**RESPONSE TO AGENCY ADVICE - SECTION 4.55(2) MODIFICATION APPLICATION (SSD-6957-Mod-1)  
CROWN SYDNEY HOTEL RESORT**

This letter has been prepared on behalf of the applicant, Crown Sydney Property Pty Ltd (**Crown**), in response to further correspondence received from the City of Sydney (**Council**) regarding a S4.55(2) Modification Application SSD-6957-Mod-1 (**Modification Application**) relating to the approved Crown Sydney Hotel Resort Development Consent SSD 6957 (**Development Consent**), located at 51a Hickson Road, Barangaroo, NSW.

Project:
915.11 Crown Hotel Sydney

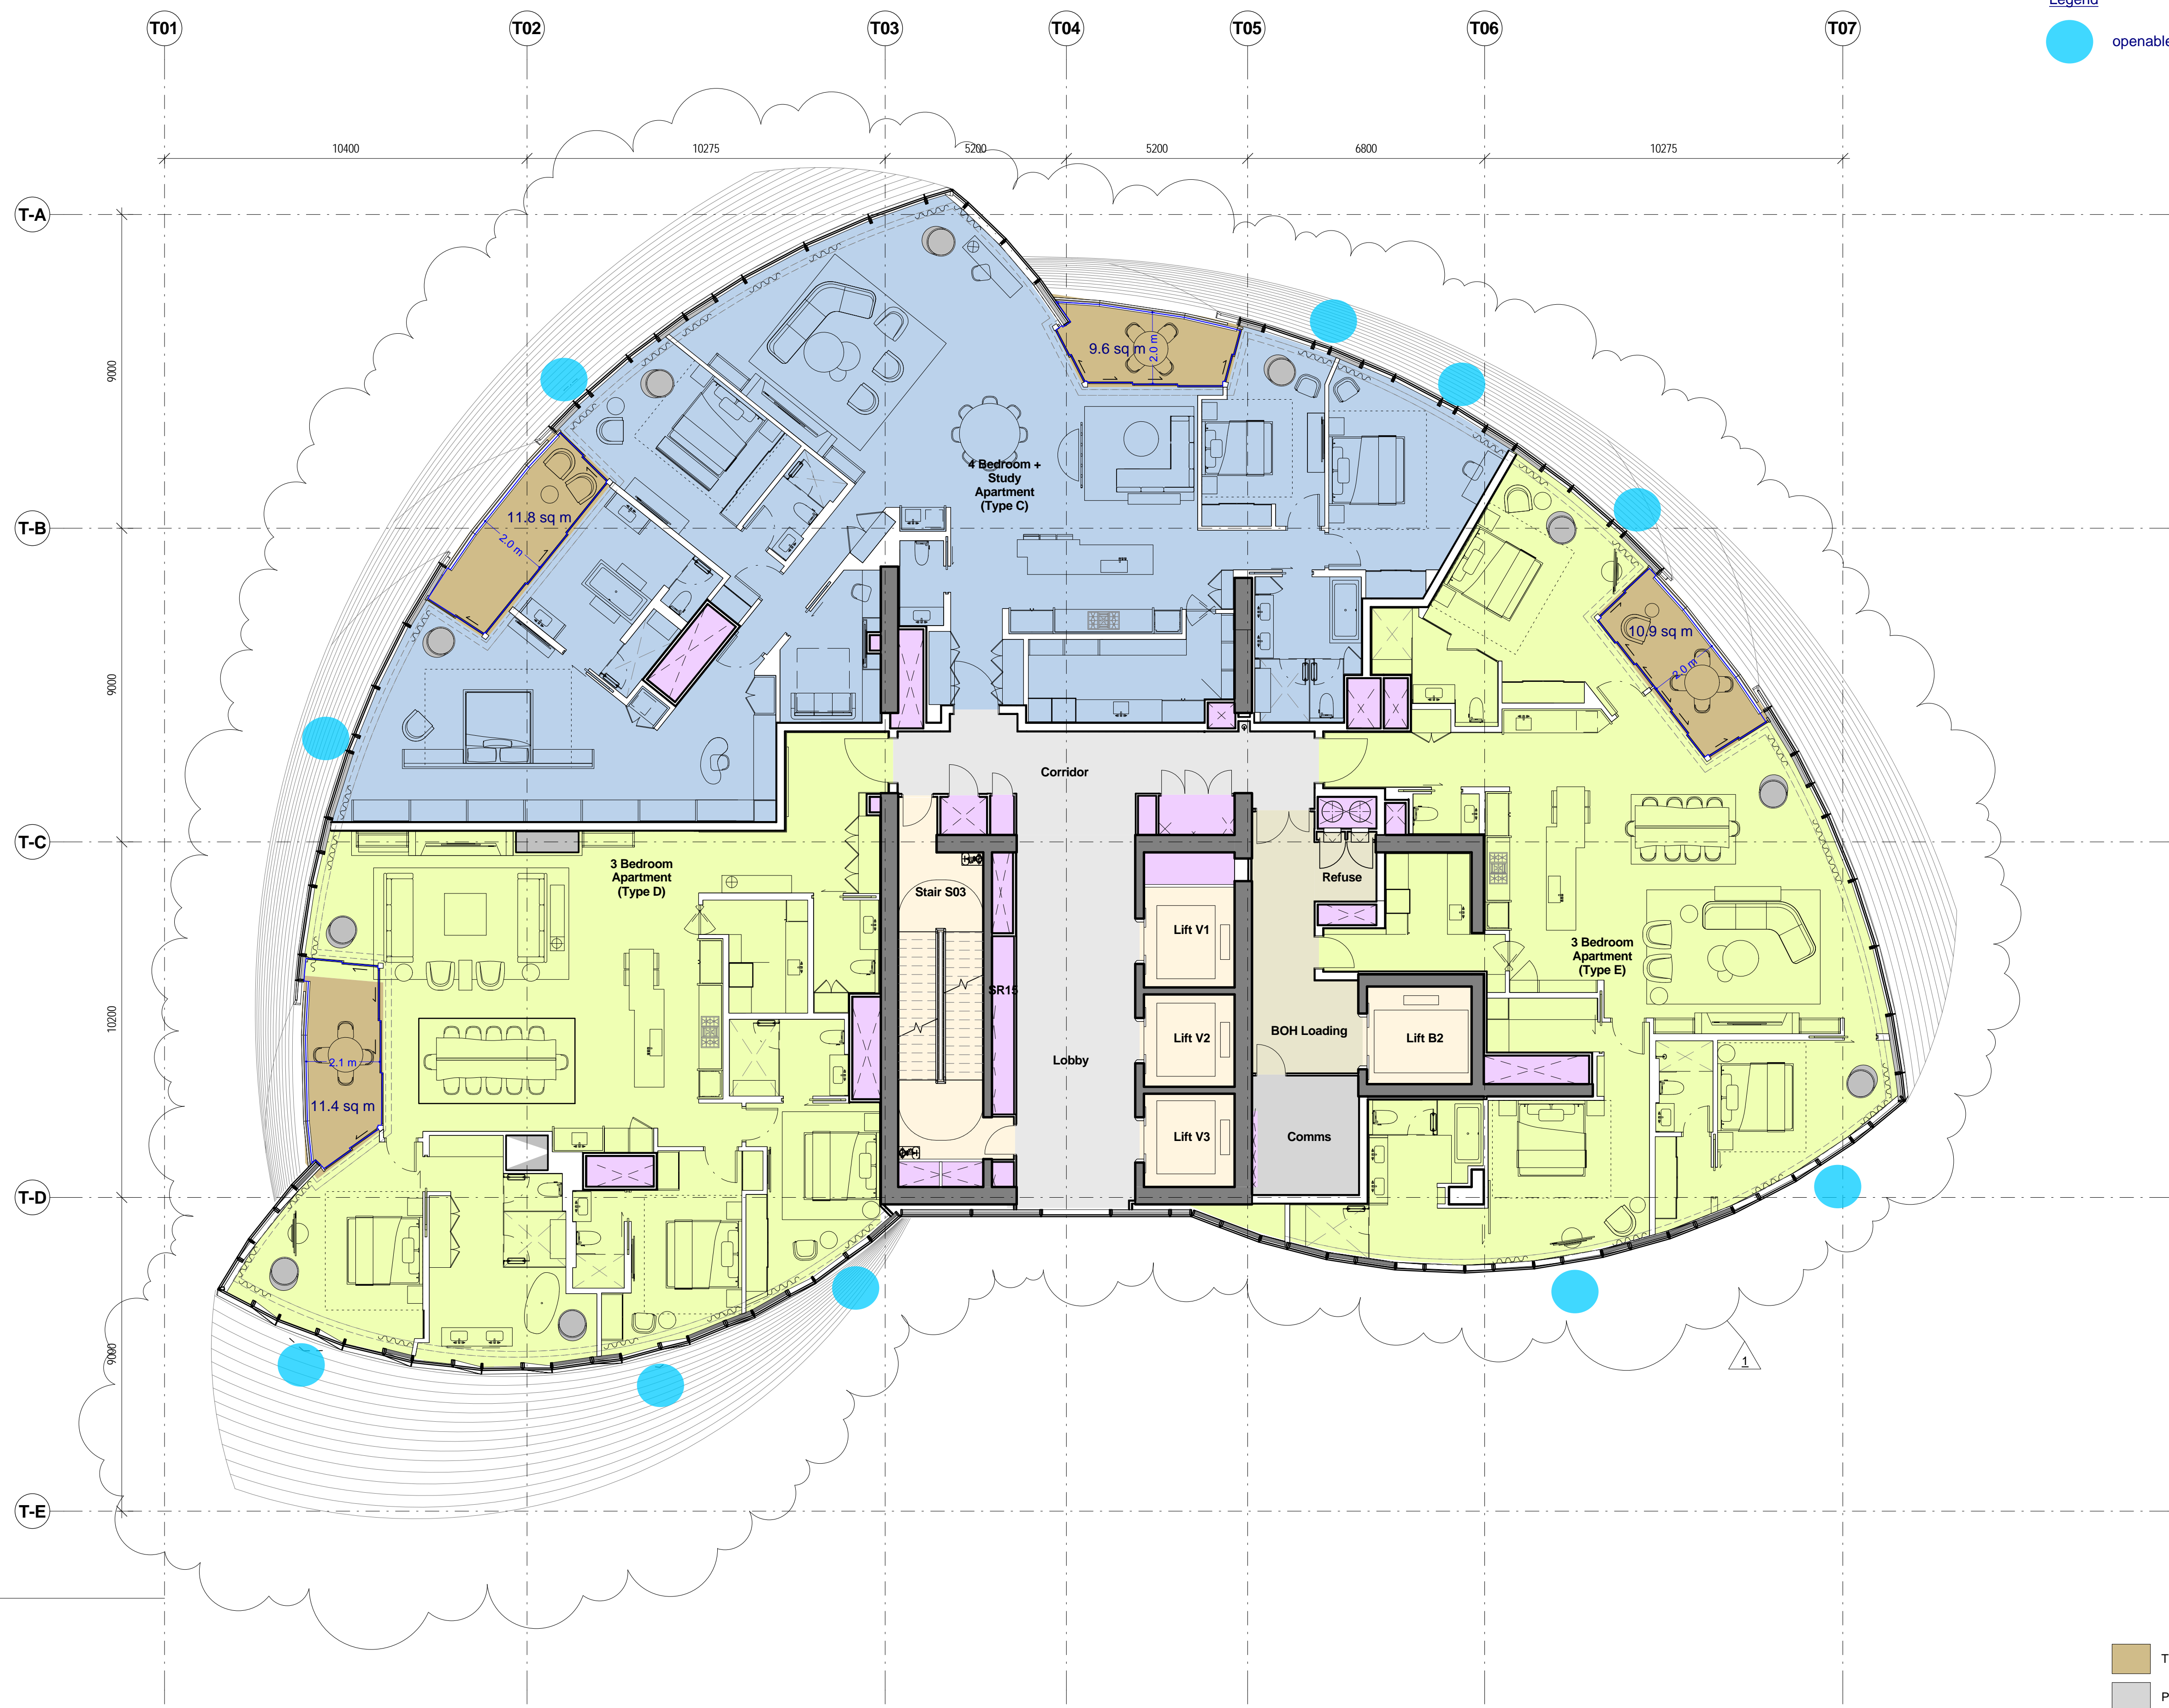
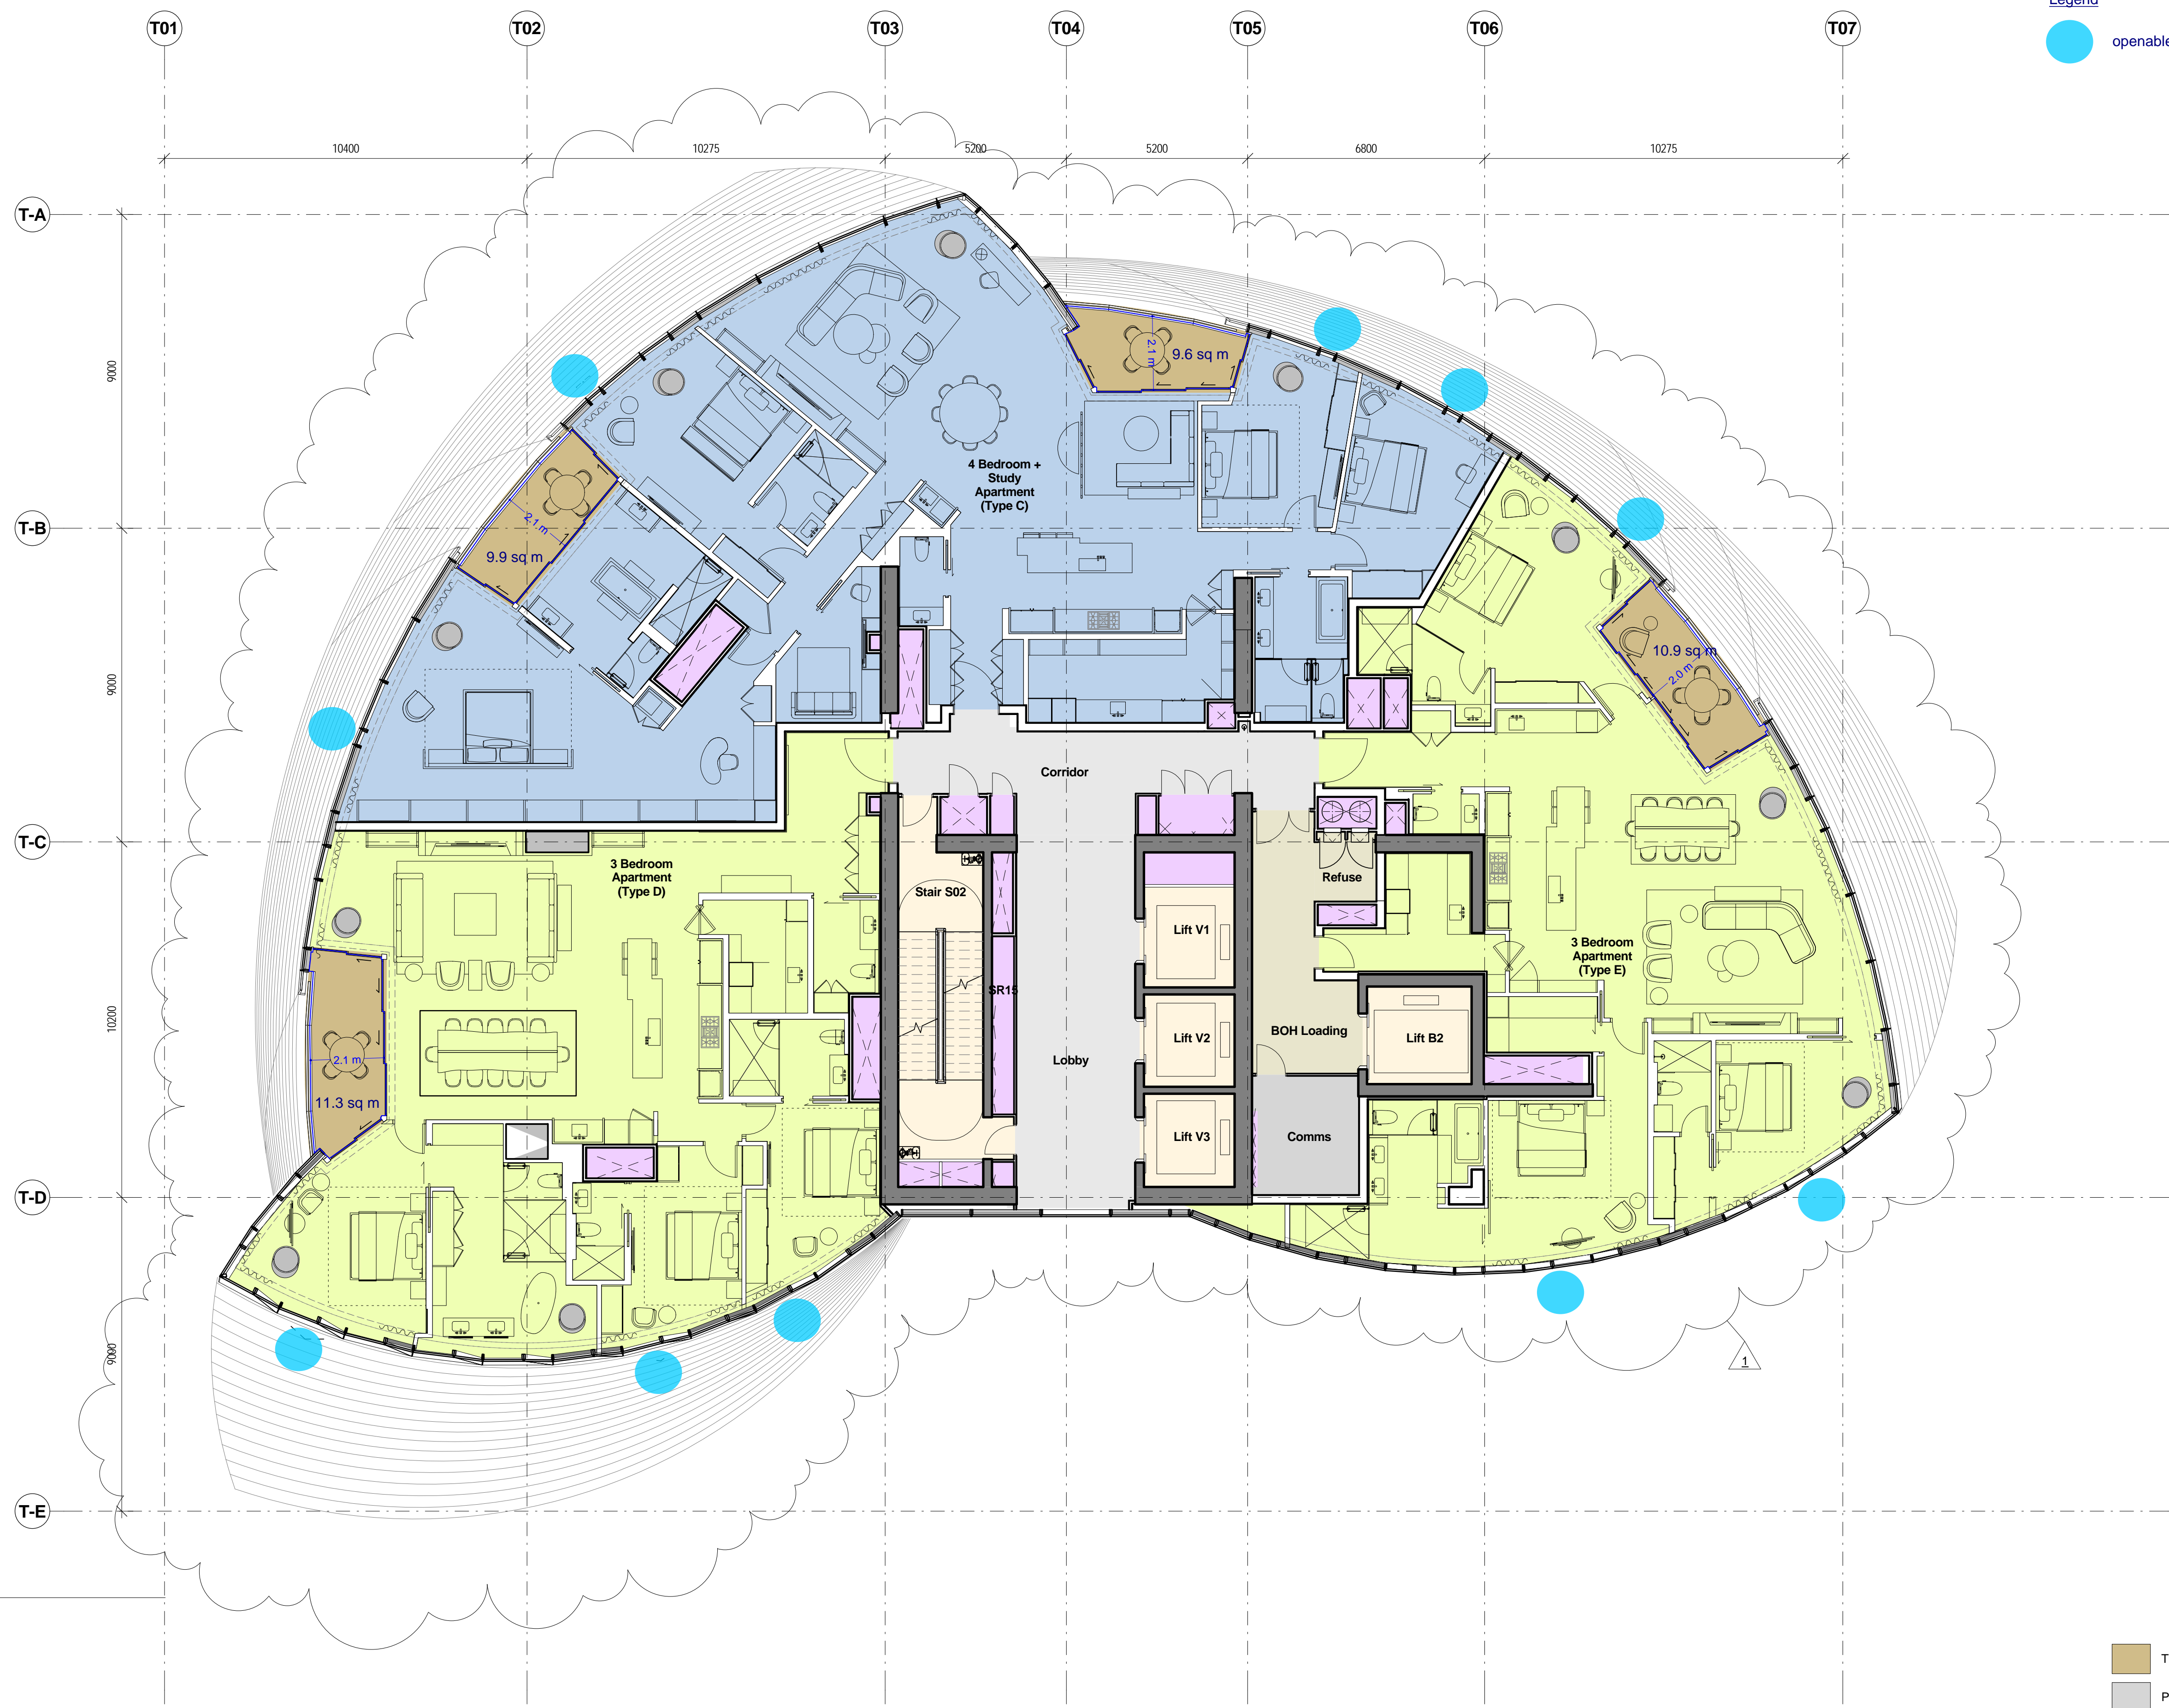
The ADG also states that to conform with the high wind balcony concession, *Natural ventilation also needs to be demonstrated*. The proposed design includes the provision of operable windows for natural ventilation to all apartments. These have been shown, for clarity, in **Attachment C**.
